CITY OF ALBUQUERQUE

Re: Project Name
3301 Candelaria Road NE
Traffic Circulation Layout
Engineer's/Architect's Stamp 08-12-2019 (G16D097)

Based upon the information provided in your submittal received 08-12-2019, the above referenced plan cannot be approved for Building Permit until the following comments are addressed:

1 Site Plan - Proposed
Scale: 1" = 20'-0"

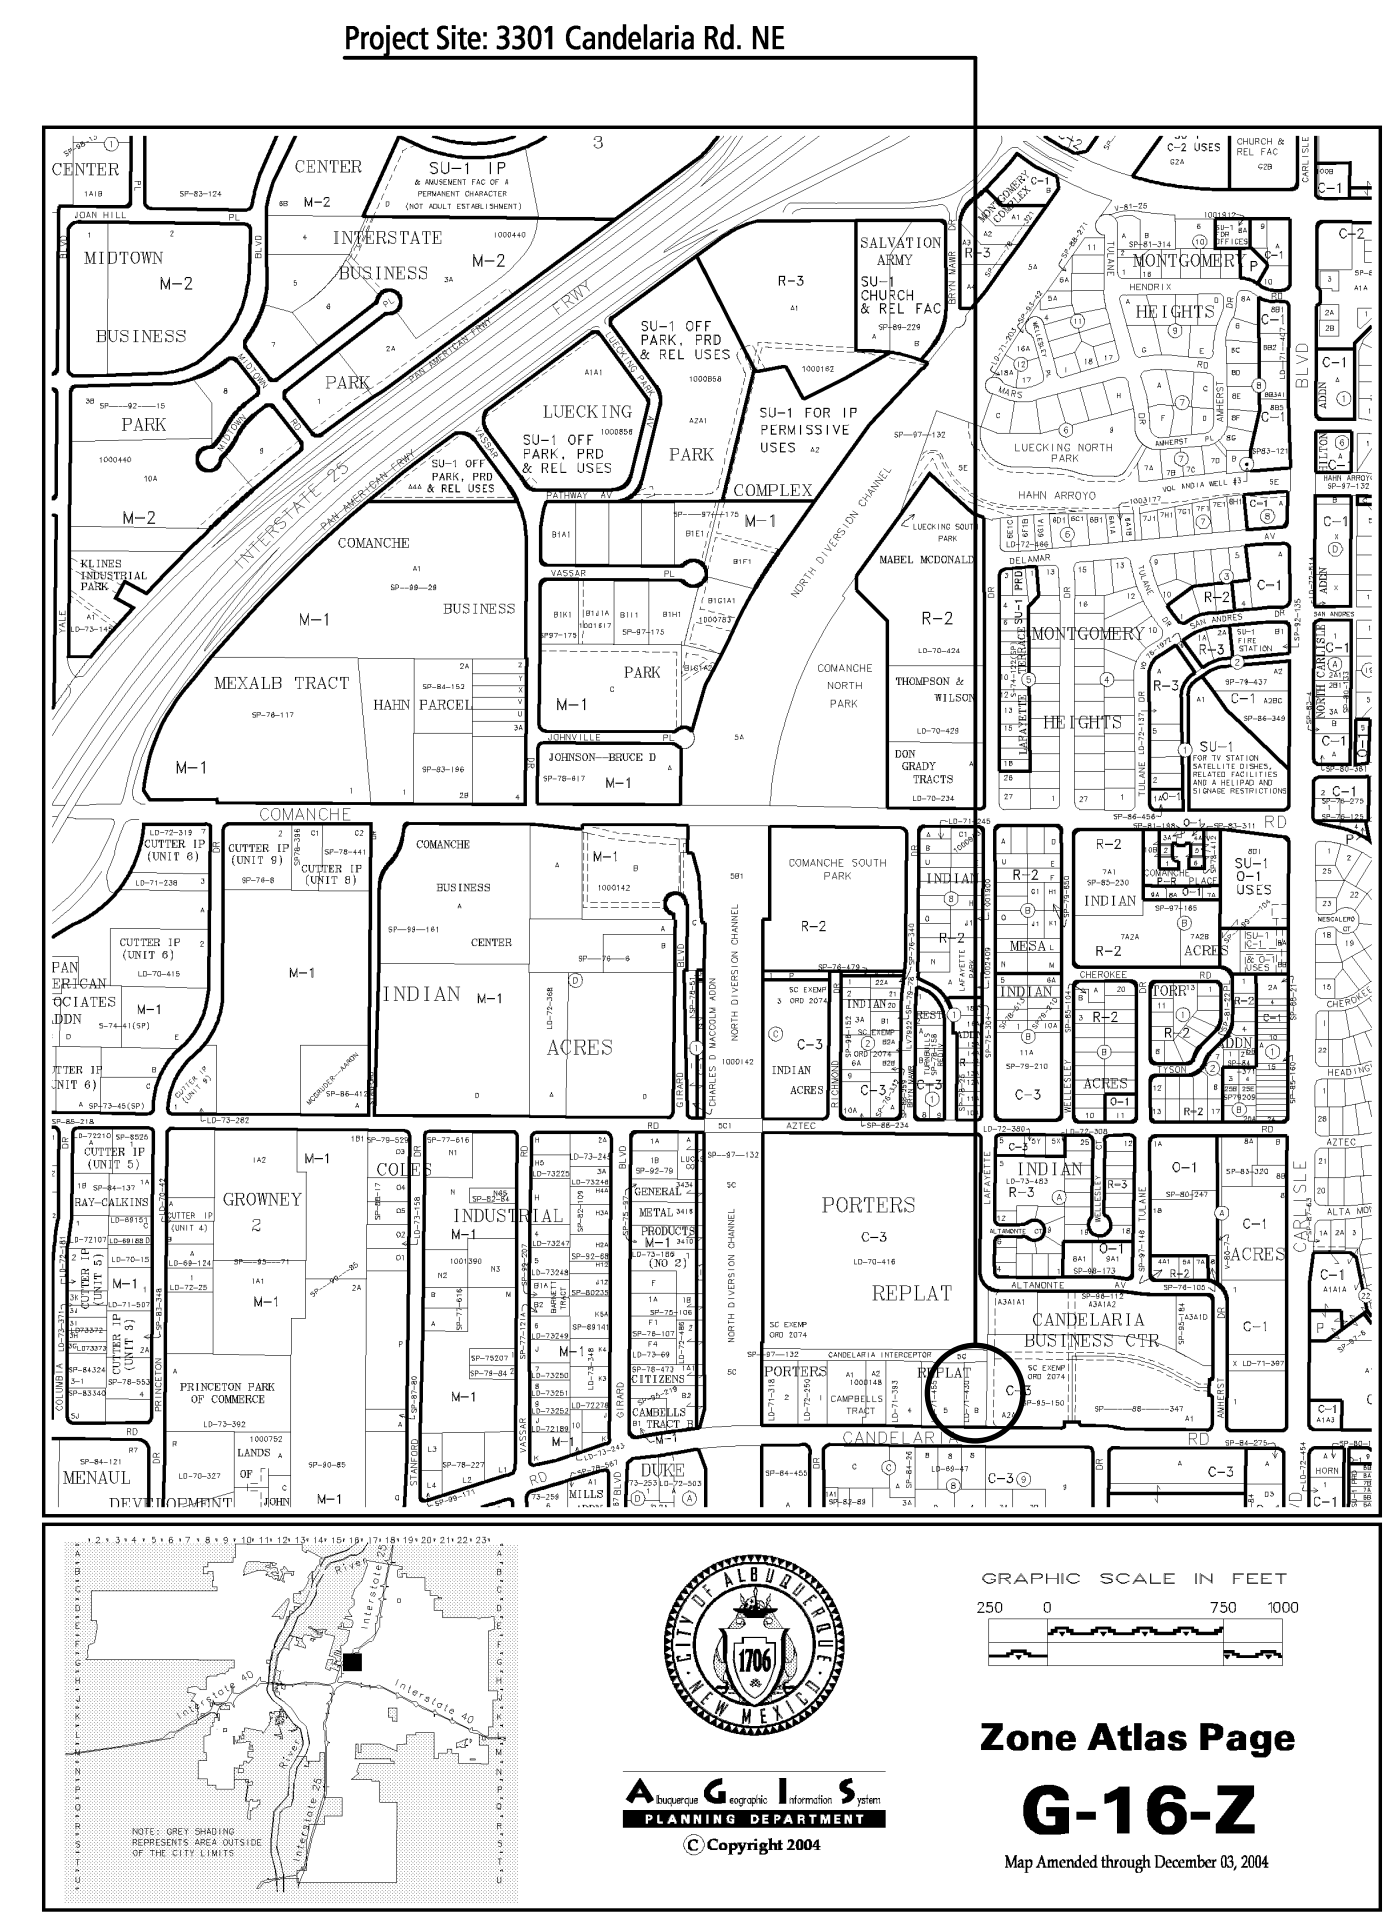
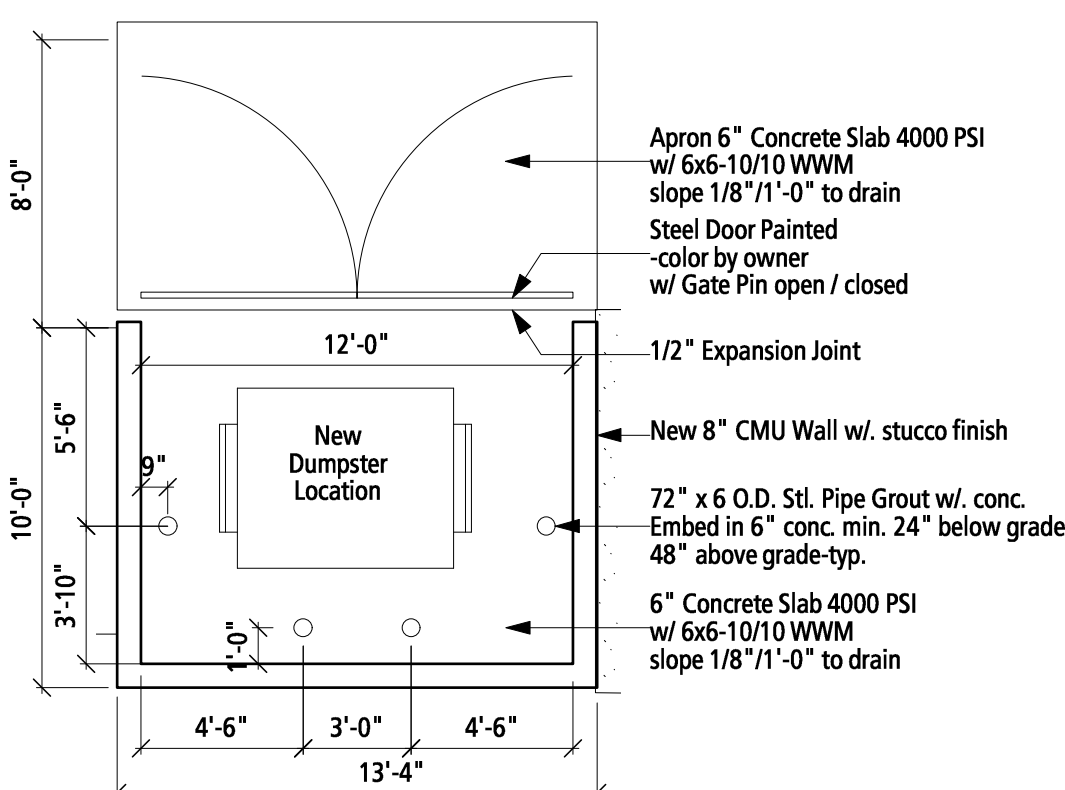
1. Part of the new drivepad portion is outside the property line.
2. List the number of parking spaces required by the zoning code as well as the proposed number of parking spaces including bicycle and motorcycle parking.

3. Please list the width for all proposed parking spaces. Some dimensions are not shown.
4. The ADA accessible spaces must include an access aisle. Van accessible aisles should be 8ft wide; all others should be 5ft wide.

10. A 5 ft. keyway is required for dead-end parking aisles.
11. Per DPM, a 6 ft. wide ADA accessible pedestrian pathway is required from the ADA parking stall access aisles to the building entrances. Please clearly show this pathway and provide details.
12. provide a copy of refuse approval.
13. It is not apparent what type of pavement surface is being proposed. A hard driving surface will be required as part of this proposed project for parking area and drive aisles.
14. Show the clear sight triangle and add the following note to the plan: "Landscaping and signage will not interfere with clear sight requirements. Therefore, signs, walls, trees, and shrubbery between 3 and 8 feet tall (as measured from the gutter pan) will not be acceptable in the clear sight triangle."
